**Consultation Response from KC,
Highways Development Management**

2024/92779 land at Providence Street, Earlsheaton, Dewsbury, WF12 8HZ

Outline application for residential development

Date Responded: 14-1-2025.

30 TOWN STREET/SYKE LANE SUBJECT TO 30MPH SPEED LIMIT

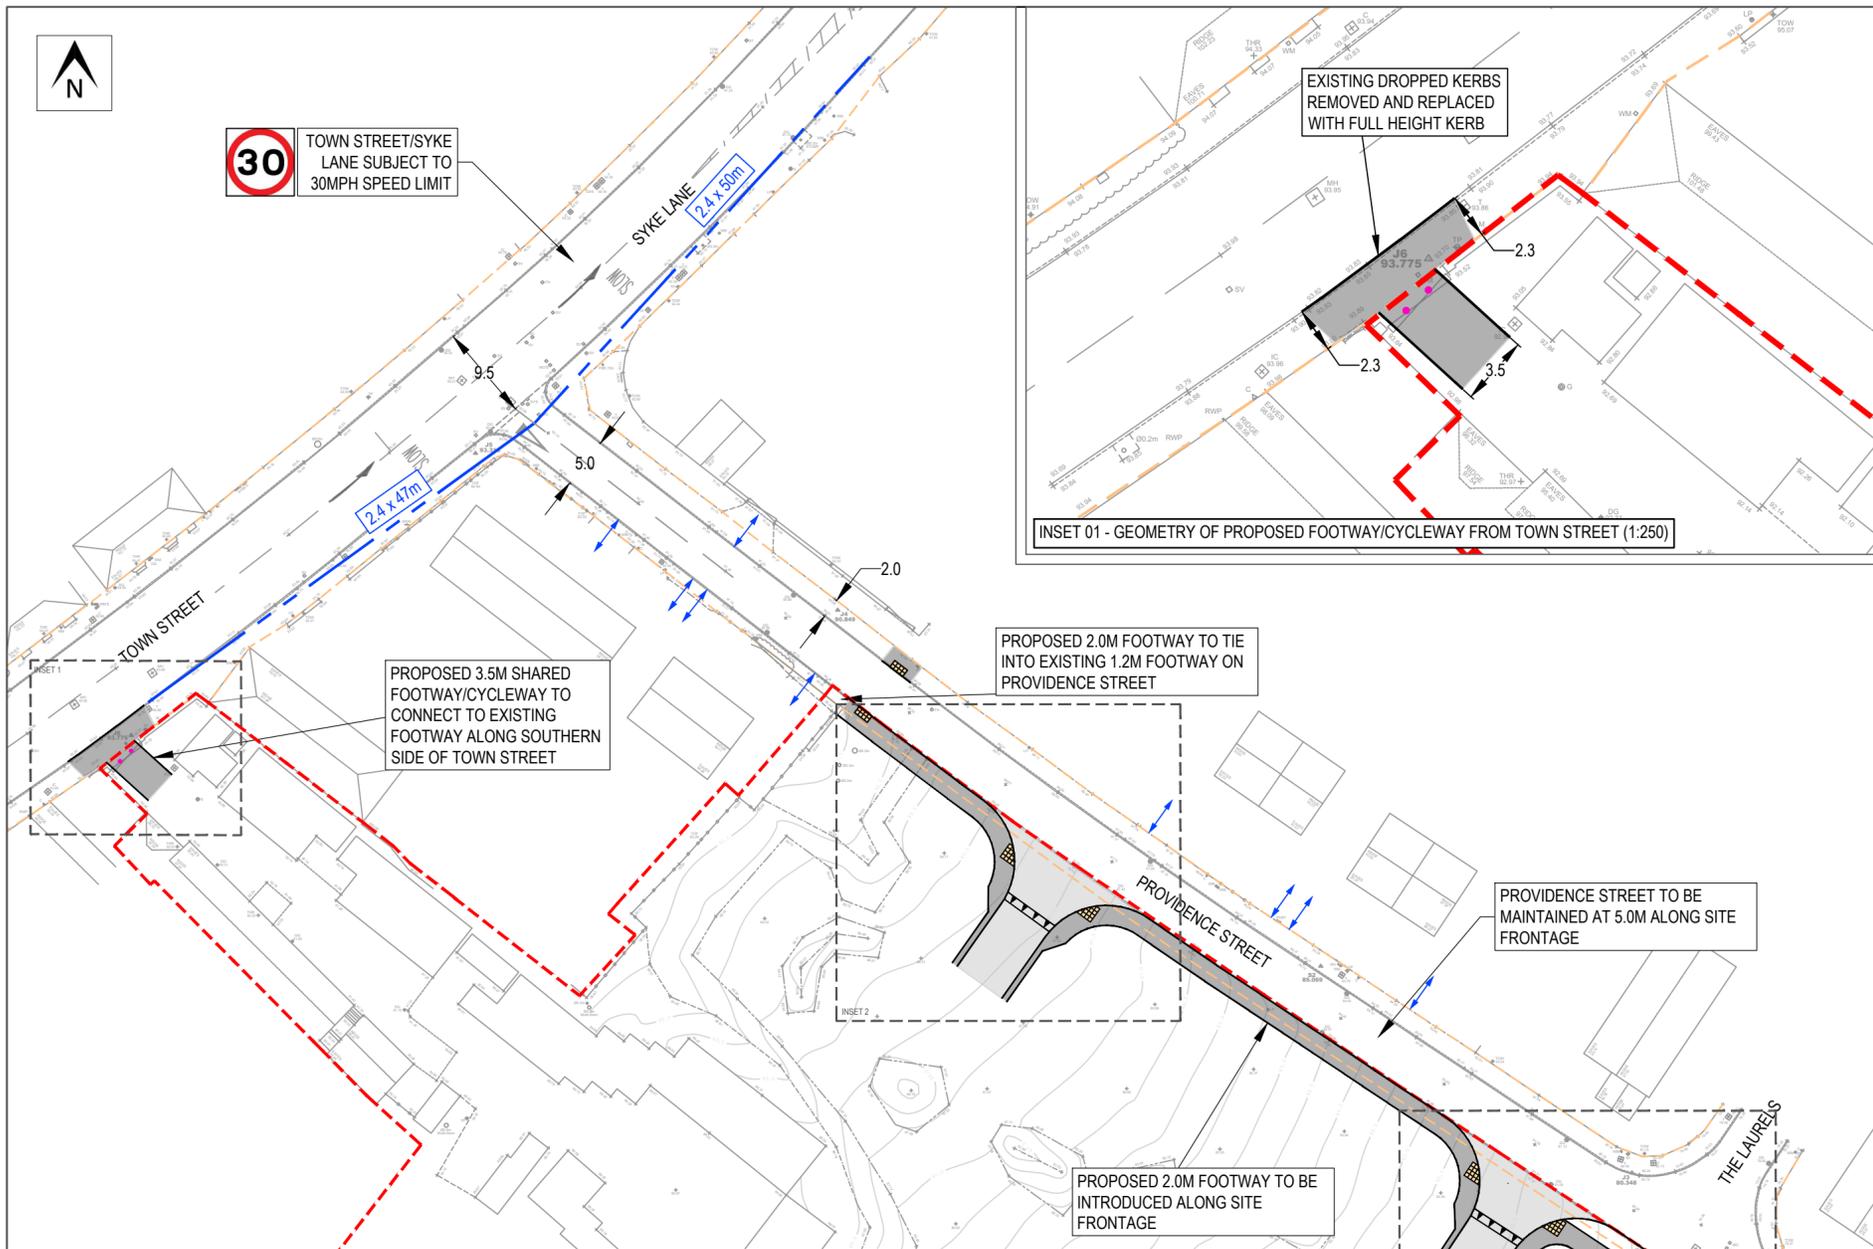
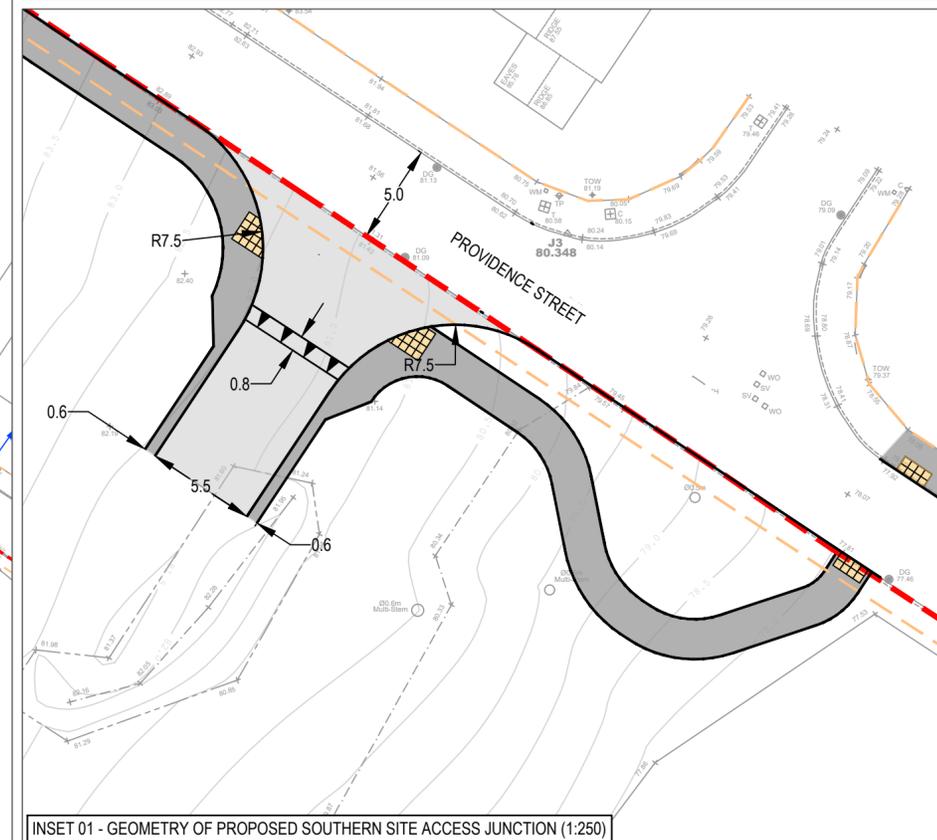
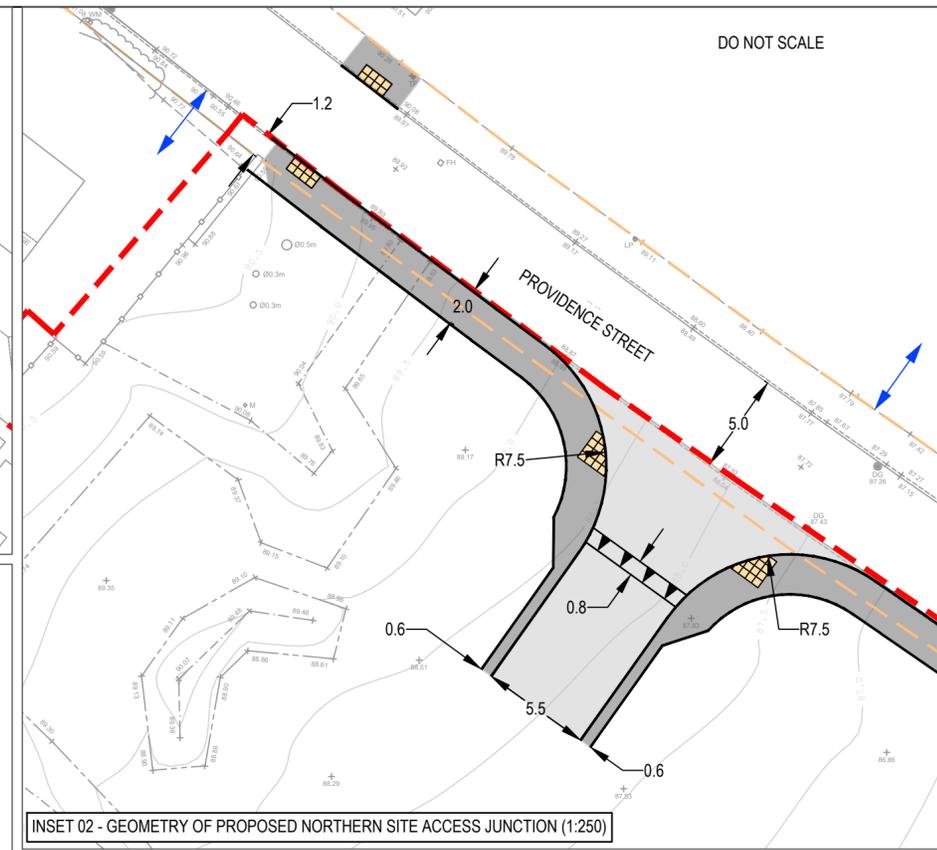
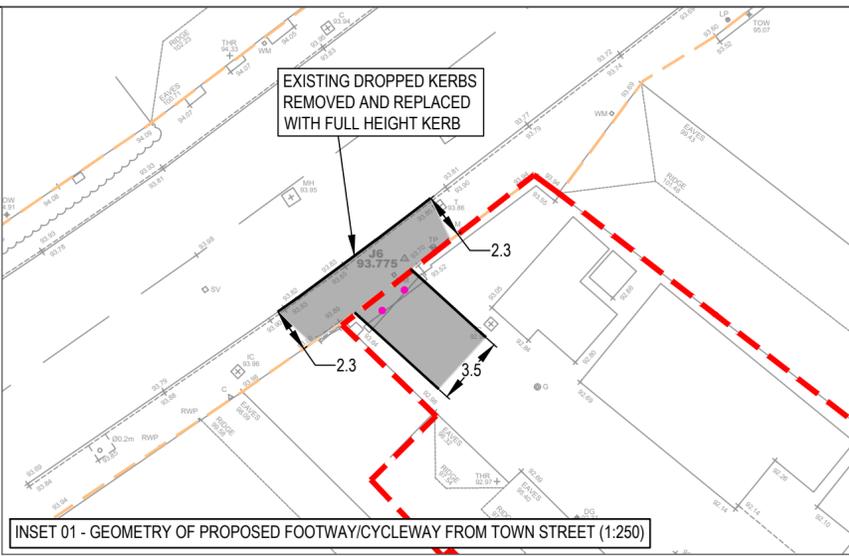
- 1, The 4m junction radii is too tight and needs to be increased to at least 6m. Swept paths should be provided to demonstrate that a 11.85m refuse vehicle can turn into and out of the site accesses.
- 2, The existing access from Homestead Mills from Town Street is narrow (not wide enough for two vehicles to pass) and sight lines onto Town Street are poor in both directions due to the width of the footway and on-street parking. HDM would therefore recommend that this access is closed, and access is taken from Providence Street.
- 3, The Highways Adoptions Team have been consulted and their comments are as follows:

Regarding the footways, we will require the footways to be extended into the site as a minimum as per our typical standard junction layout standard detail attached. The ramp will need to be at least 6 metres in from the Give Way line to ensure vehicles turning in have cleared the existing road before traversing the ramp to ensure rear end

shunts area avoided.
